# EAGLE RISING FILING NO. 1

# GRADING AND EROSION CONTROL PLAN

SEPTEMBER 2018

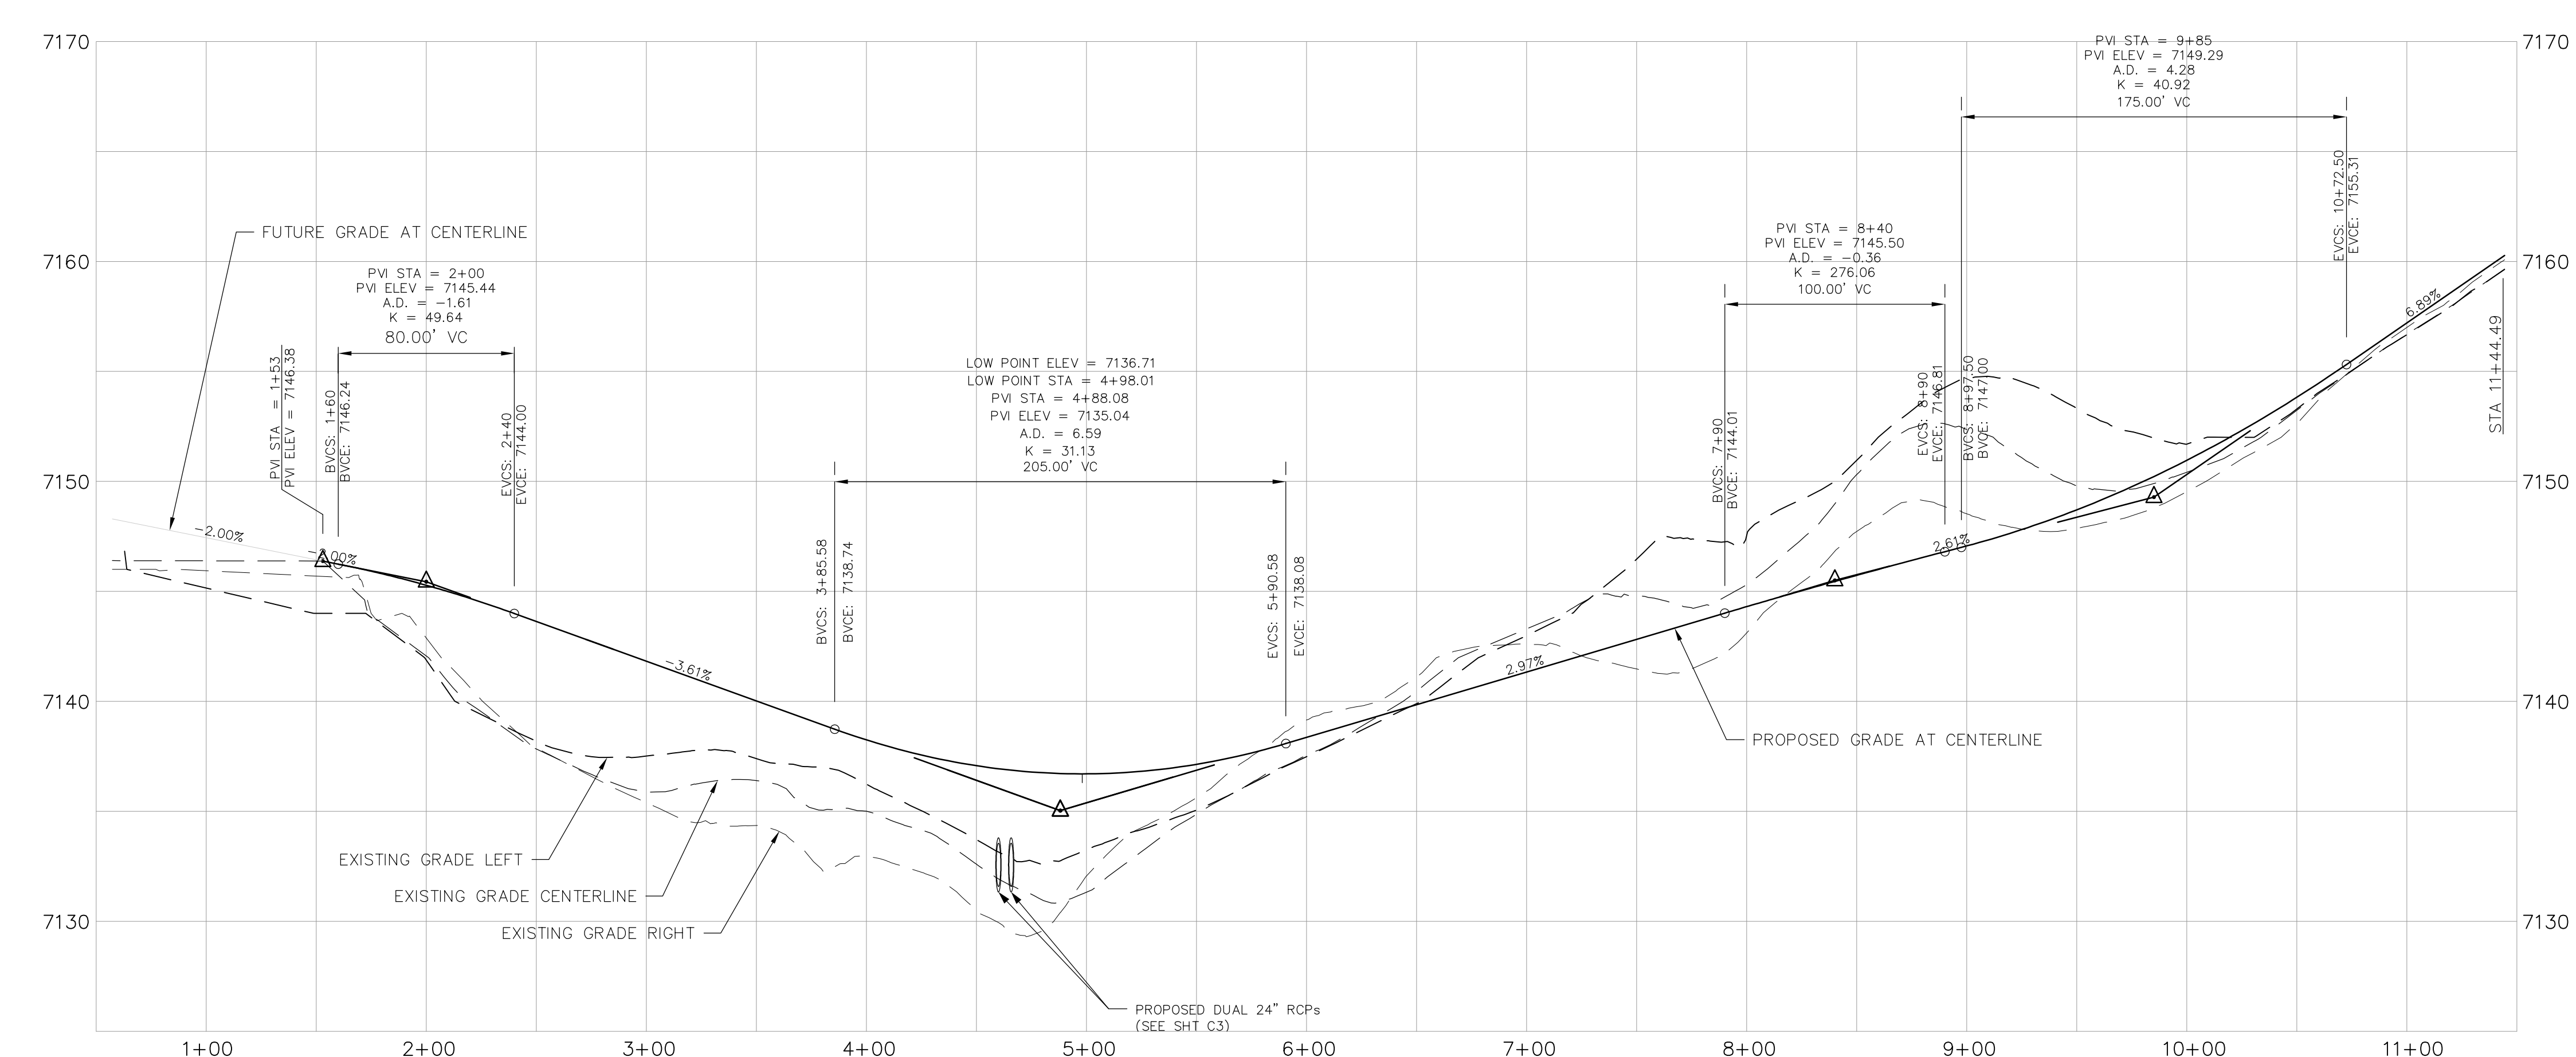
Update these and all references to DOT (DPW) and DSD (PCD).
